## ASSESSMENT REPORT

### Building R1, Barangaroo South SSD 6513 MOD 3

This report provides an assessment of a section 96(1A) modification application lodged by Lend Lease (Millers Point) Pty Ltd (the Applicant) seeking to modify a State significant development application (SSD 6513) for the construction and use of Building R1 as a pub at Barangaroo South within the City of Sydney local government area. The application seeks approval for design amendments to the ground floor planter boxes, four signage zones and minor ground floor design and layout amendments.

9.53
6061 T6
ALUMINIUM
PLATE

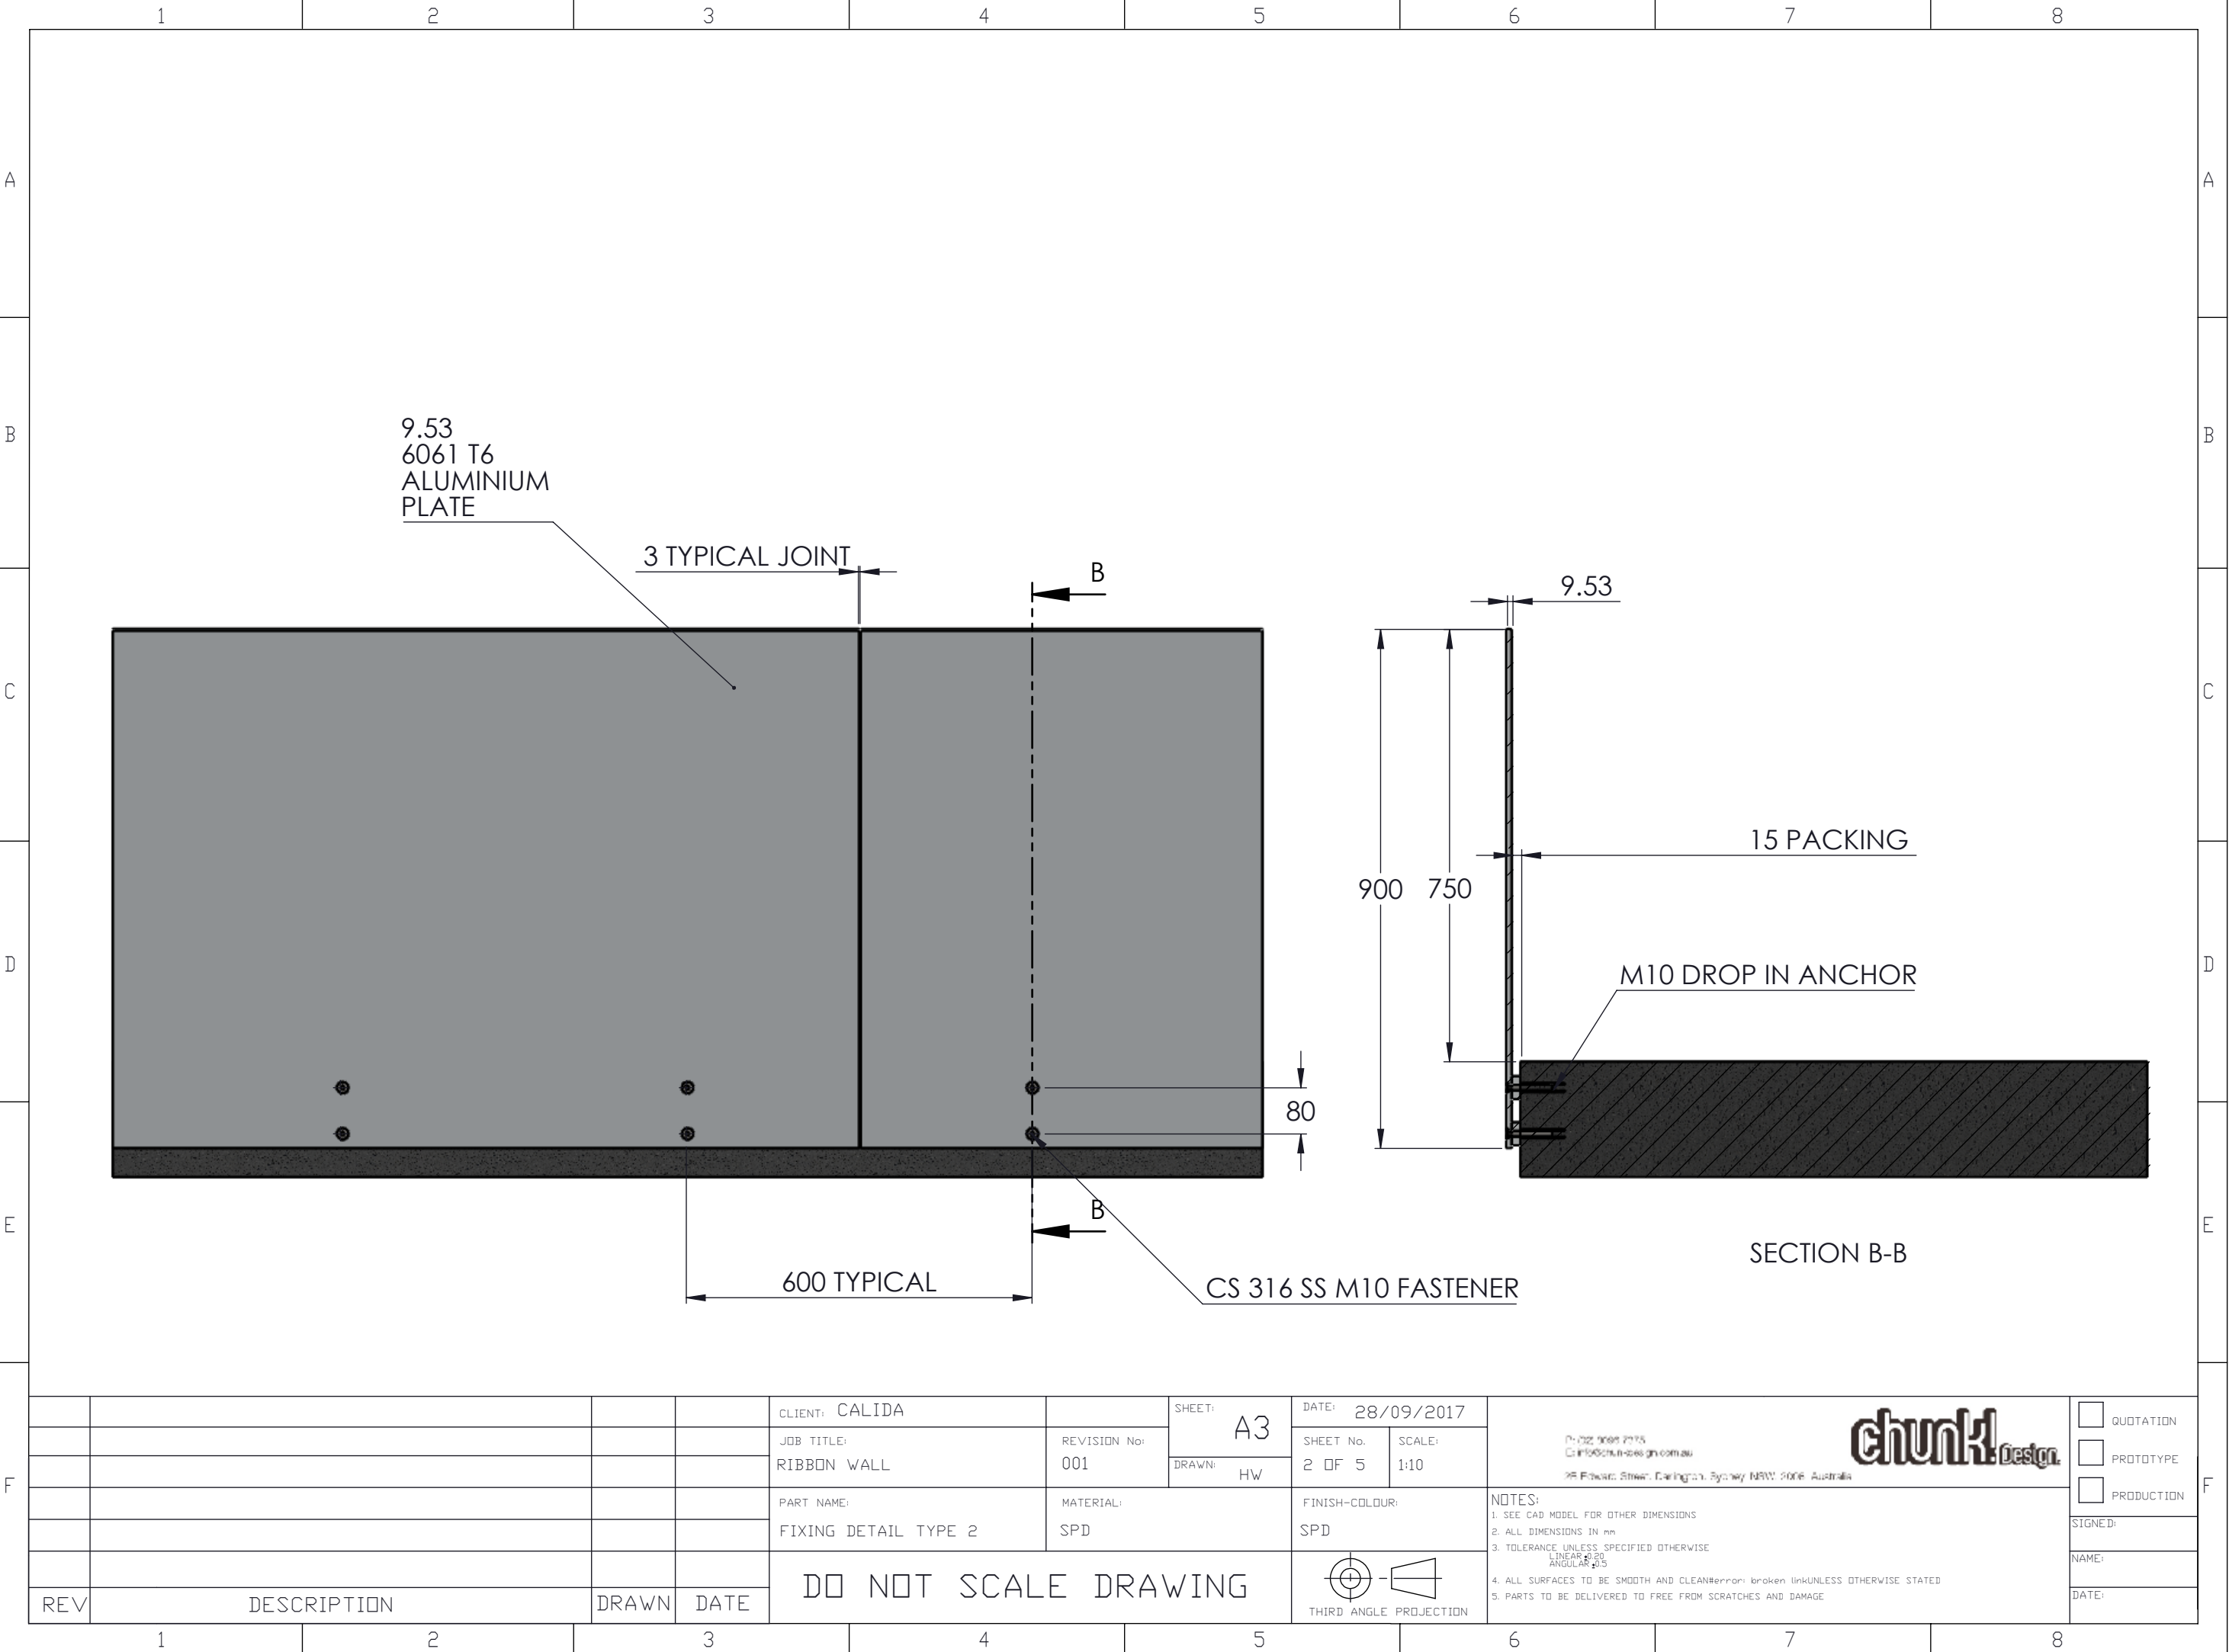
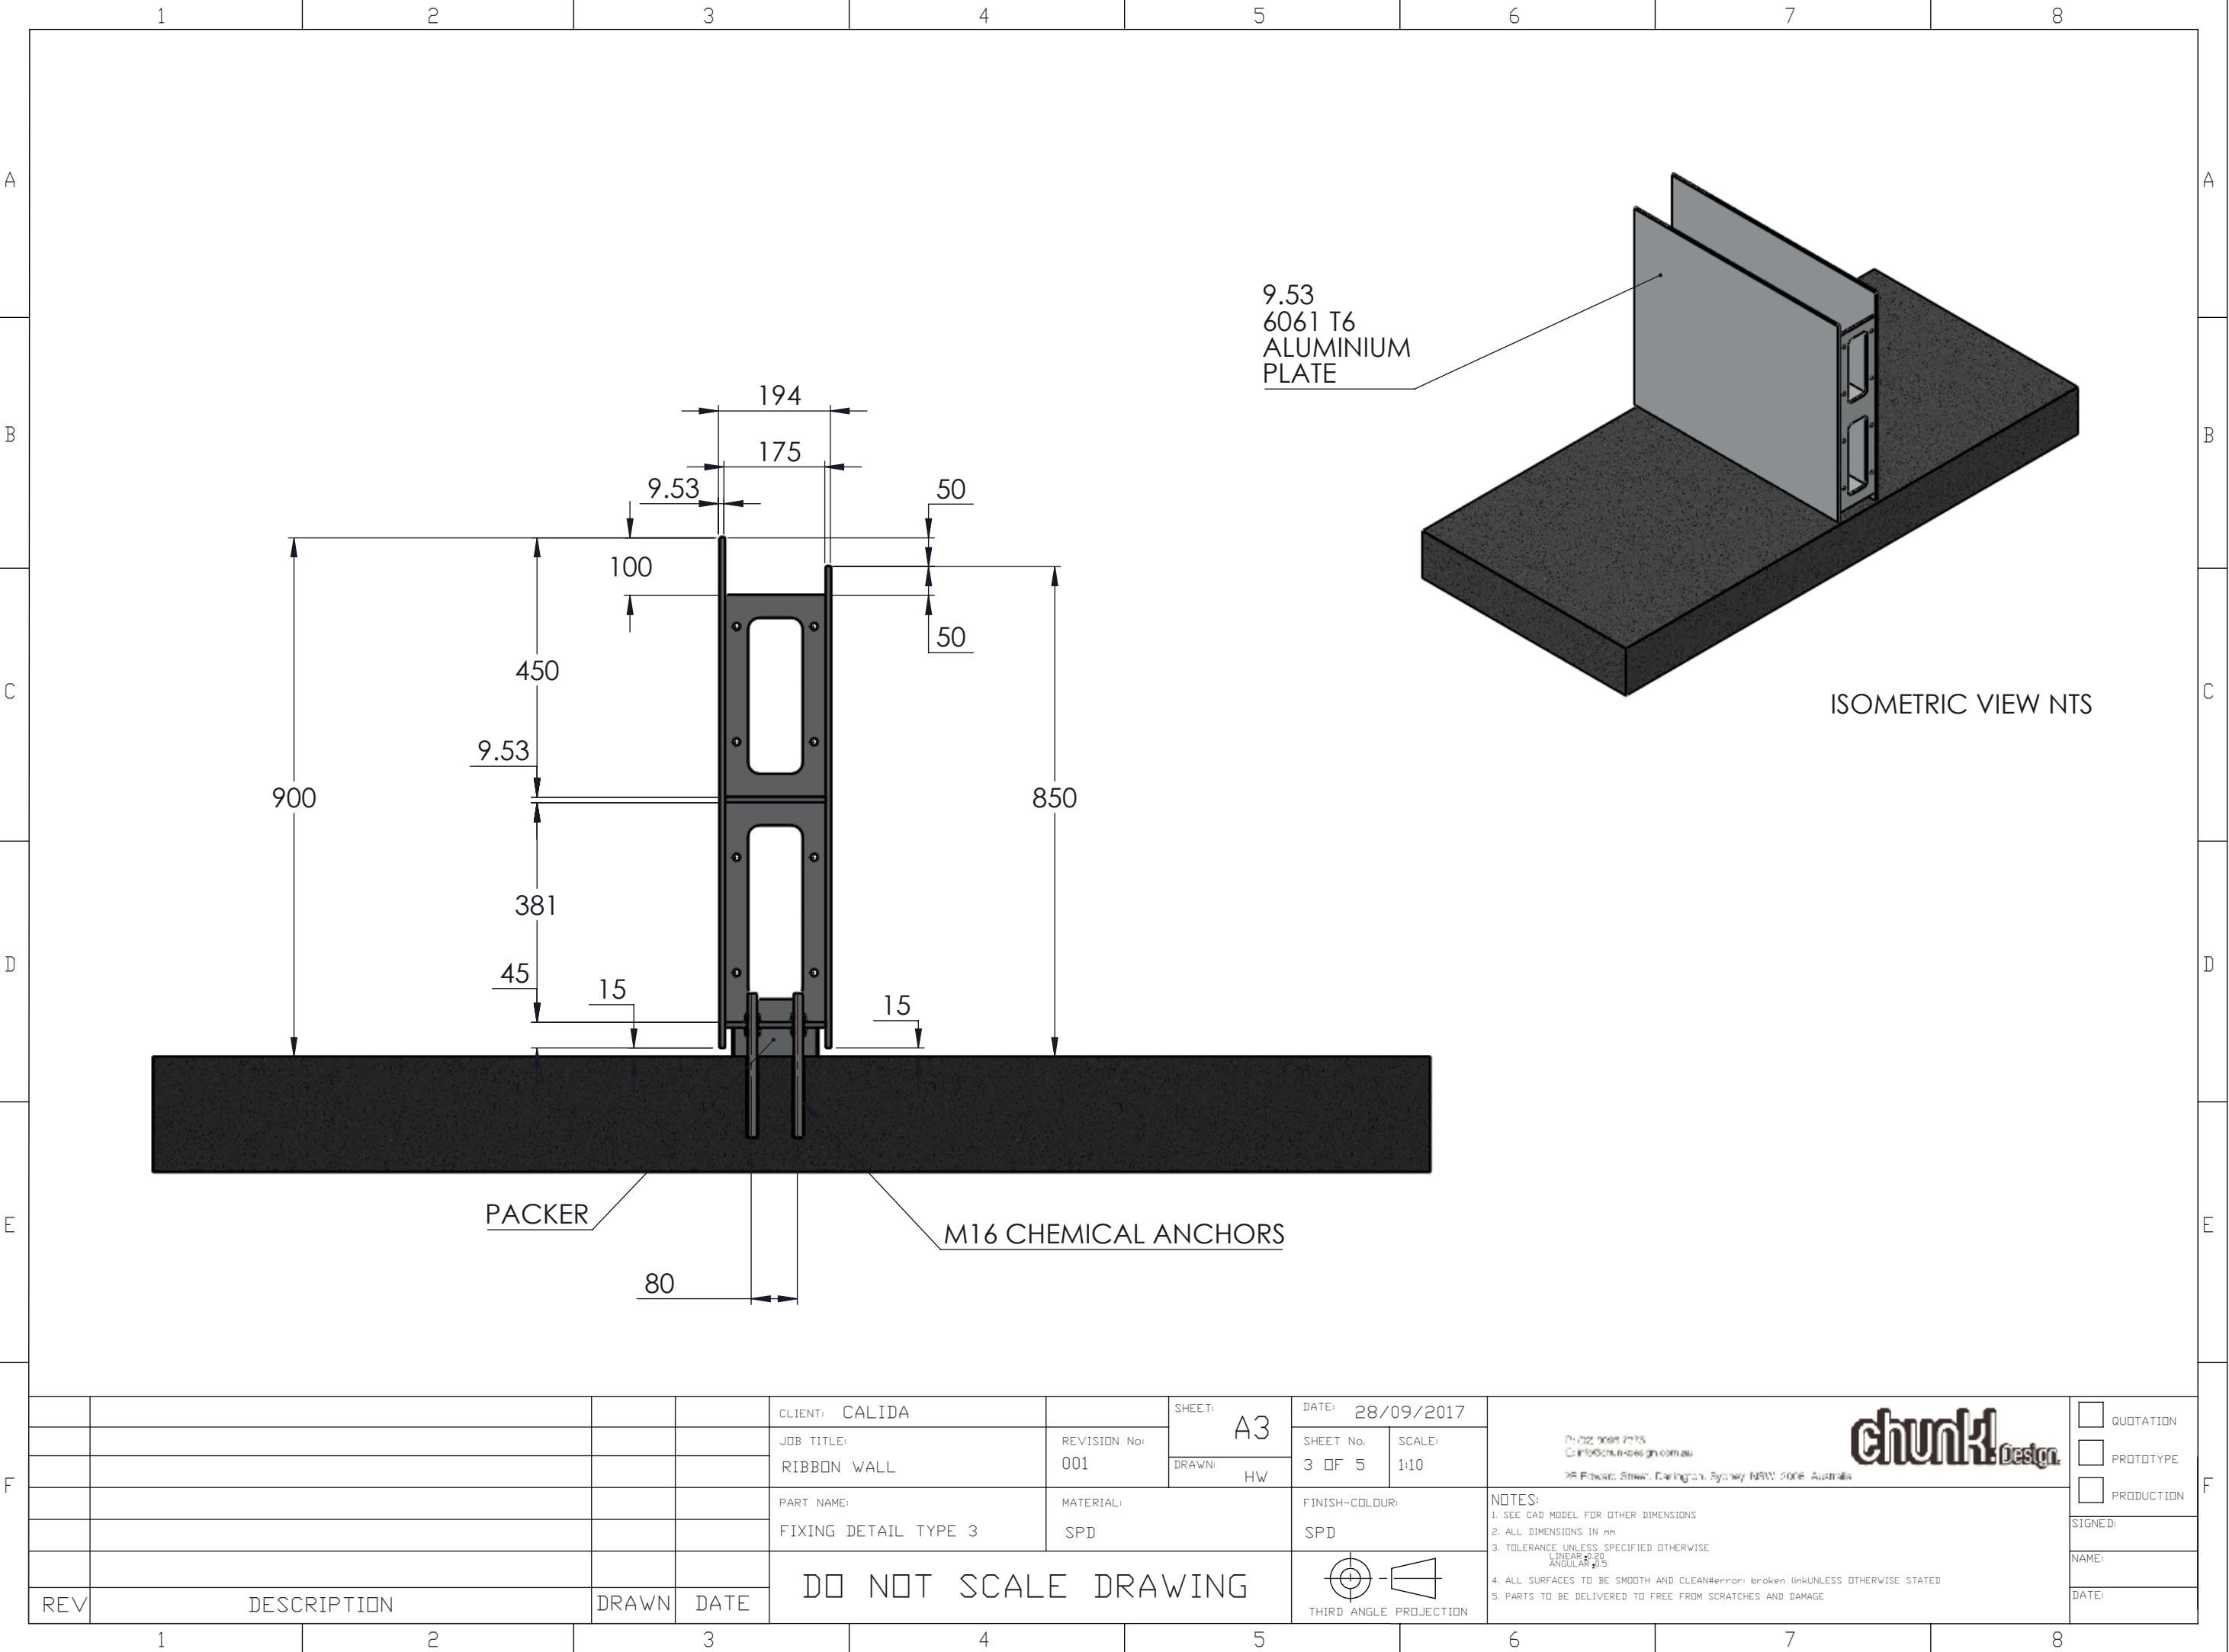
- the need for more detailed plans showing the folded metal planter boxes and how the proposed signage zones integrate with structures
- inadequate consideration of Crime Prevention Through Environmental Design (CPTED) principles
- the proposed new seating zone in the south-eastern corner of the building being isolated from other areas of the building which would limit the ability of staff to properly managed patrons within that space.

Council requested more detailed plans be provided showing the folded metal planter boxes.

In response to Council's concerns, the Applicant provided additional diagrams 'for information' which illustrate the proposed folded metal planter boxes in more detail (**Figure 6**).

The Department has reviewed the information provided and notes the proposed planter boxes have been architecturally treated, integrated into the design of the existing landscaping and appropriately sized to ensure they do not interfere with or detract from the adjoining public domain. The landscaping and materiality (steel) of new planter boxes would be consistent with the approved design.

Given the above, the Department supports the design of the modified planter boxes and is satisfied they would not adversely impact on the surrounding public domain.

drawing title
Ground Level Fitout Plan

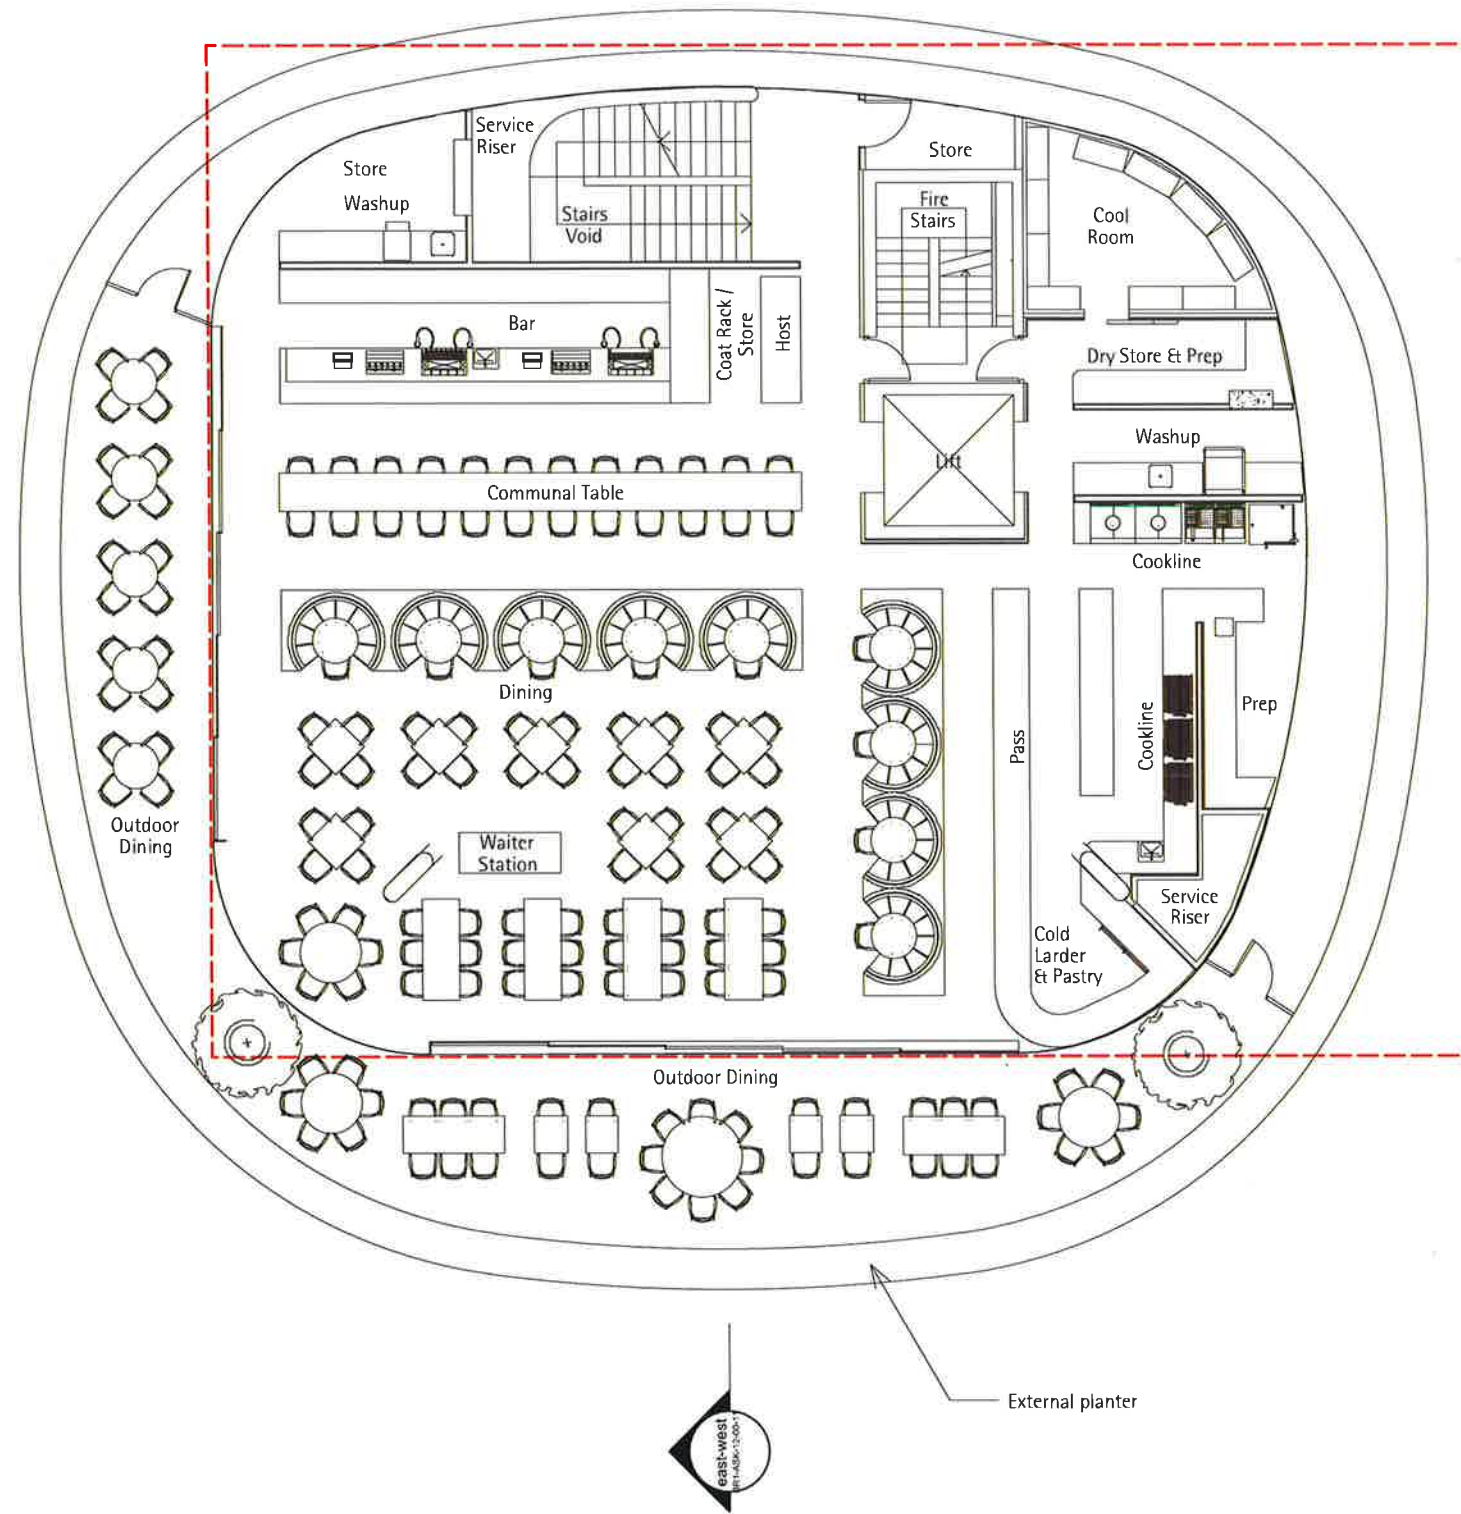
Council raised concern the proposed new ground floor seating zone in the south-eastern corner of the building (**Figure 4**) is isolated and visually separated from other areas of the building which would limit the ability of staff to properly managed patrons within that space. Concern was also raised CPTED principles had not been thoroughly considered as part of the application.

In response to Council's concerns, the Applicant acknowledges that while the new seating area is separate from the primary outdoor seating area, it is located in a highly visible location within the public domain at Barangaroo South as it is located at a key gateway to the precinct with limited screening (i.e. the corner of Shelley and Lime Streets). Further, the Applicant considered the low height design of the folded metal planter box in the south-east corner provides appropriate separation and demarcation of the public and private domain without limiting opportunities for casual surveillance.

The Department acknowledges Council's concerns but is satisfied CPTED principles have been suitably considered in the design of the additional seating area. Further, the Department is satisfied patrons in the new seating area would safely and be efficiently managed by staff in accordance with the approved POM for the premises. The new seating area would also activate the south-eastern corner of the building and the adjacent public domain and is therefore supported.
